## Application for a Non-Material Amendment Following a Grant of Planning Permission

Conversion of existing gym building to residential flats comprising five single-storey dwellings (2x1-bed apartments, 2 x 2-bed apartments and 1 x 3-bed accessible apartment) with private rear garden space and associated car parking.

19/00573/REG3

JOB REF-SERIES-DWG NO. REVISION
A-22027-70-001_C2

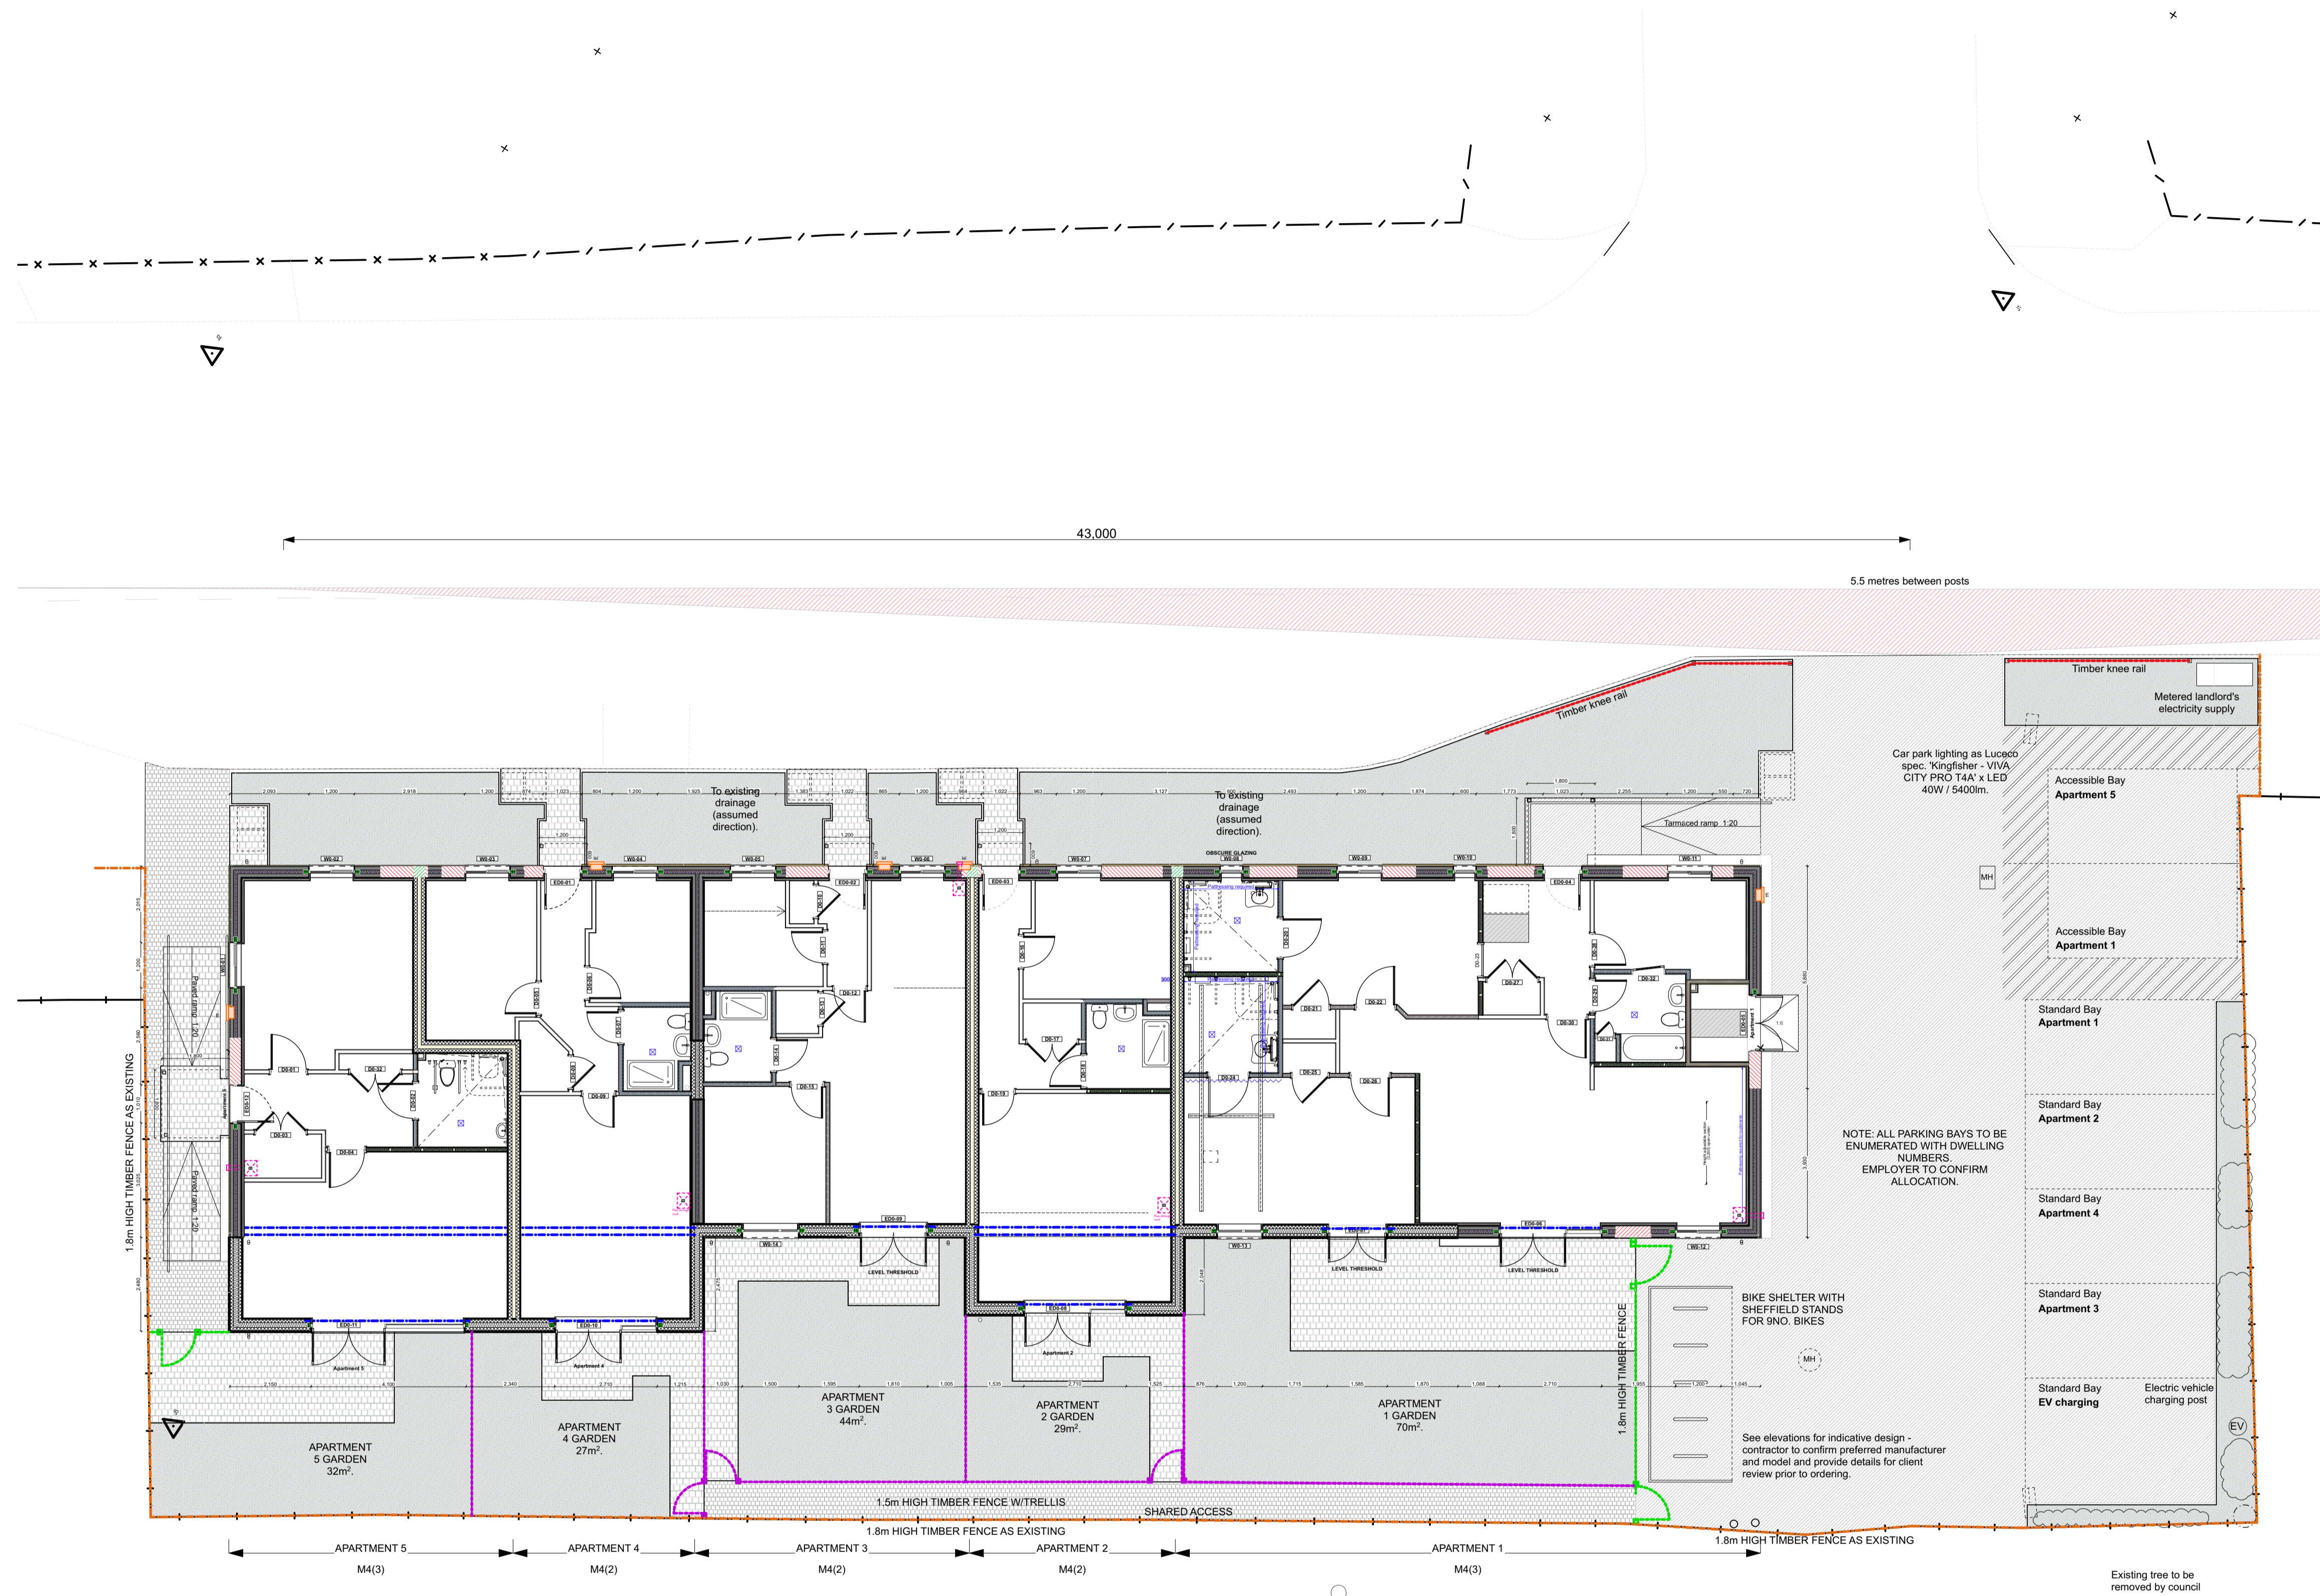
Confirmation of the proposed materials and colours  
Omitting PV panels  
Omitting solar shading to rear elevation  
Windows changed from aluminium to white UPVC  
Electric meter boxes added to elevation drawing  
Store doors added to gable to apartment 1  
Revised rear garden/footpath layouts - more direct access  
Omit metal railings to front footpath replace with timber knee rail  
Omitting planting to front and rear gardens, replaced with grass
